**From:** [ericwtidmore@gmail.com](mailto:ericwtidmore@gmail.com) on behalf of [Eric Tidmore](#)  
**To:** [Harmon Rita T.](#); [Cherne, Curtis](#); [joe slagle](#)  
**Cc:** [Vernon Ambos](#); [mike walla](#)  
**Subject:** Fwd: 7500 Holly NE  
**Date:** Tuesday, September 02, 2014 1:38:43 PM

At the request of Eric Tidmore of Trinity Construction I have performed a site visit at the 7500 Holly NE Dental Office project today to verify the construction progress and the general compliance of the site construction with our approved Grading and Drainage Plan permitted for this project. The COA Hydrology approval letter was dated December 9, 2013 on our plan that was stamped on 11/26/2013.

## GRADING AND DRAINAGE PLAN

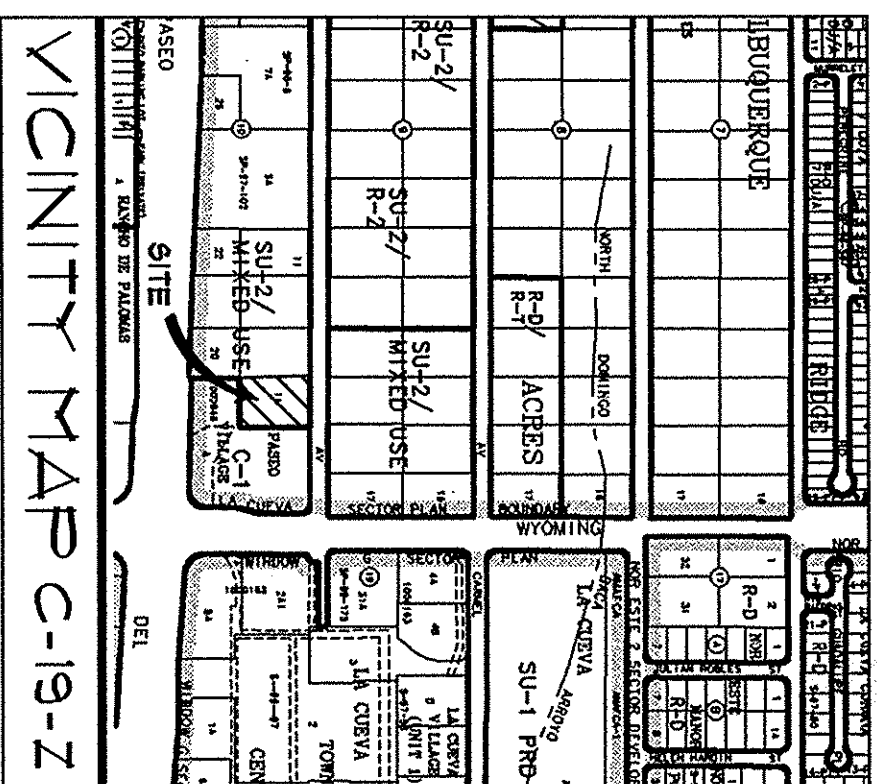
Hi Mike I hope you had a good Labor Day weekend! I wanted to touch base with you so we are all on the same page with regards to the drainage culvert on the northside of the building. I was under the impression the existing drainage is fine to leave as is but we need to add the permanent galvanized plate to the side walk section and we need to add an additional diamond plate cover to the section that runs from the side walk to the street. Can you please confirm this is correct. If so we will go ahead and get the other piece of diamond plate ordered and installed asap. Thanks again for coming out last week on short notice.

- Installation of permanent sidewalk culvert covers on site (2 each) and in the public R.O.W. on Holly Ave. (1 each). Apparently, the galvanized diamond plate that will be the final covers for these 3 structures has not yet been delivered by the supplier and so temporary covers have been installed. The temp covers do not extend the entire required length and have not been properly anchored but once the correct covers arrive they will be installed.
- Slope protective landscaping rock has not been completely installed on the north and west side of the site.
- An as-built topographic survey of the site has not been completed yet.

Until these items are complete we cannot submit our Engineer's Certification to the COA. However, the construction does appear to direct runoff flows as required to downstream drainage facilities and all other site improvement that are described, or referenced on our plan appear correctly installed. I can at this point say that all completed work on this site has been

Hi Rita, See Mike's email below. I just wanted to keep us all in the loop. We will order a new diamond plate cover to fit the existing culvert that runs from the side walk to the street and then all will be good. The surveyor will be onsite today to get the as-built and then all will be good. Please let me know if you have any other questions. Thank you all for your help last week in getting our temporary CO.

Your understanding of the north culvert condition is correct. I will indicate the smaller width on my Engineer's Certification once you get me the as-built survey.
